Our Ref: 22/00216/FUL

APPLICATION NO: 22/00216/FUL DATE ACCEPTED: 24 MARCH 2022

PROPOSAL: Proposed replacement of existing floodlights

LOCATION: Brightlingsea United Football Club North Road Brightlingsea Essex

Block Plan 1:500

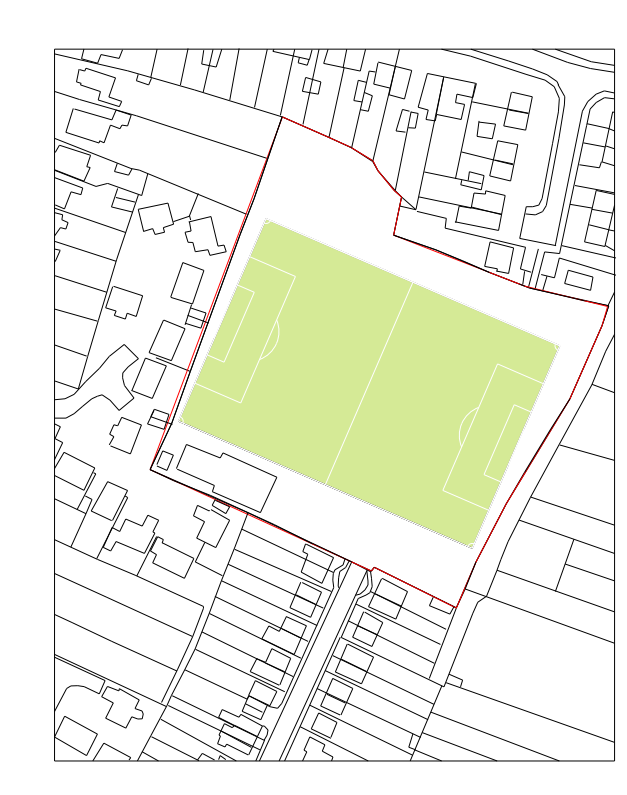
**The indicated scales on the block plan are incorrect as the scales are actually doubled, for example 1:100 should be 1:200 and 1:1250 should be 1:2500. Please amend so the plans are consistent.**
